From: Nicola Swann [REDACTED]
Sent: 03 March 2021 10:23
To: Planning.Responses <Planning.Responses@arun.gov.uk>
Subject: Pagham responses

Pagham Parish Council considered the following applications at a meeting of its Planning Committee held on 2nd March 2021. It would make the following comments:

6.4 P/21/21/HH – 6 The Green Pagham PO21 4RZ. Loft conversion to form new first floor with front and rear dormer projection. RESOLVED: to OBJECT to the proposed development. The proposals are not in keeping with the street scene of The Green (single storey dwellings), represent overdevelopment of the site, and are unneighbourly, all contrary to policy D DM1 of the Arun Local Plan. The

Proposed

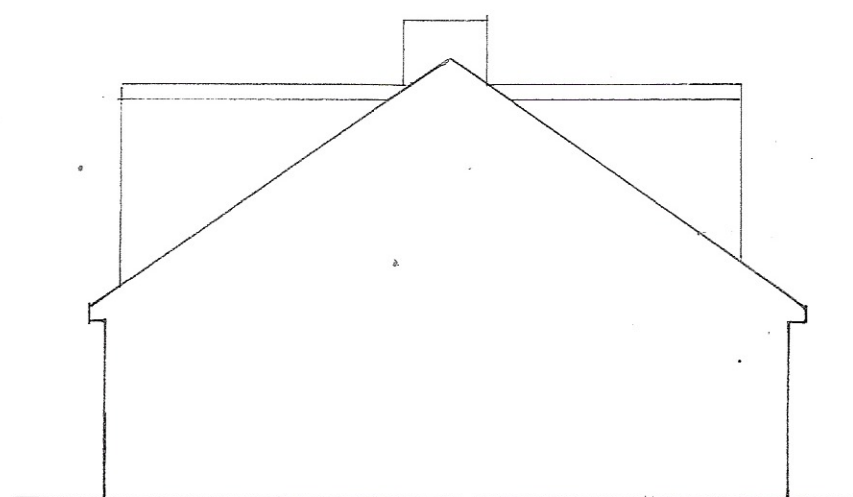
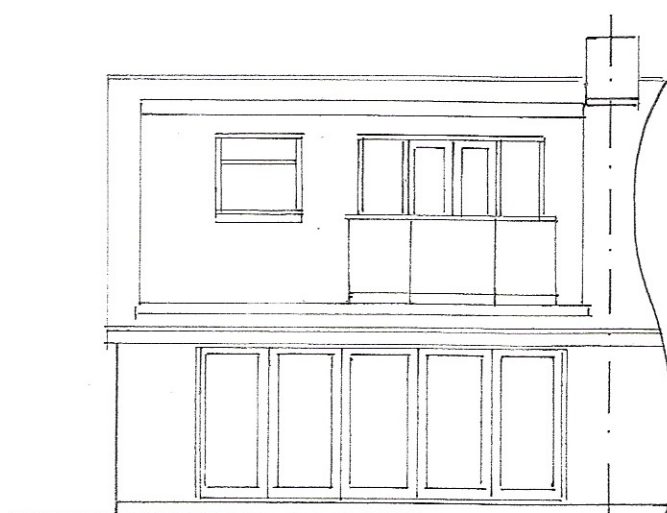
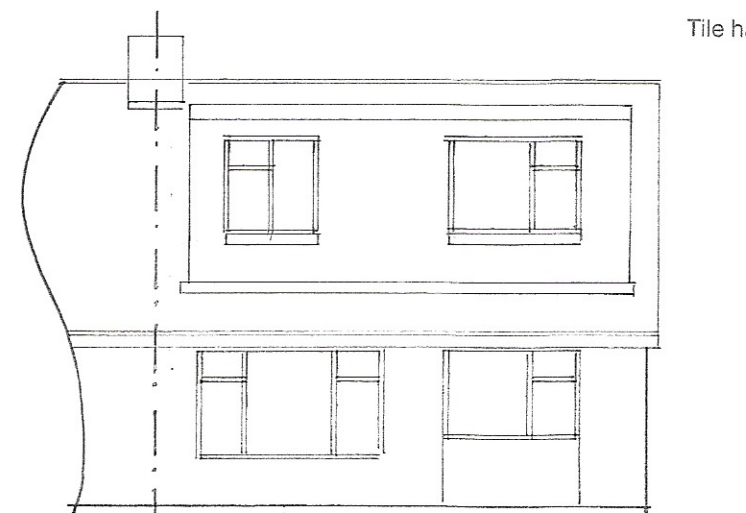
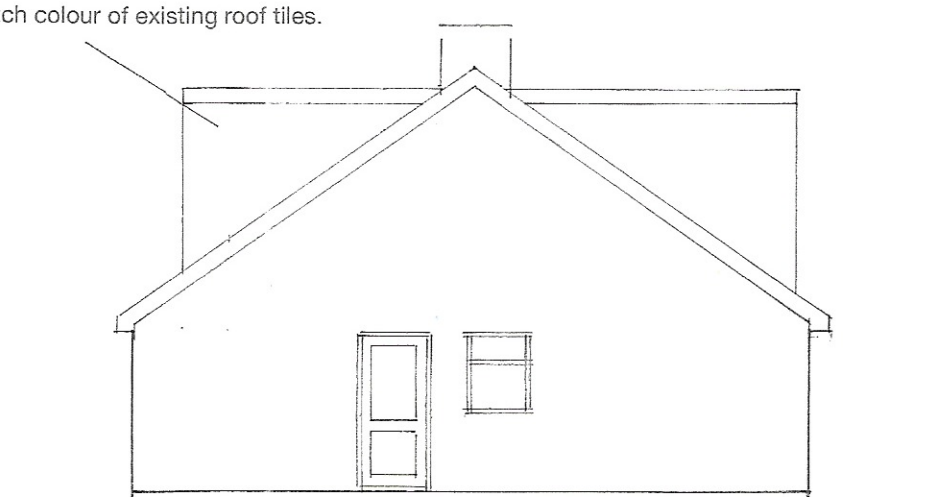
Pagham Village Design Statement (a material planning consideration) classifies The Green as part of the Kings Beach Estate and at page 10 development criteria specify new or replacement buildings or extensions should not vary significantly in height or bulk from those nearby.
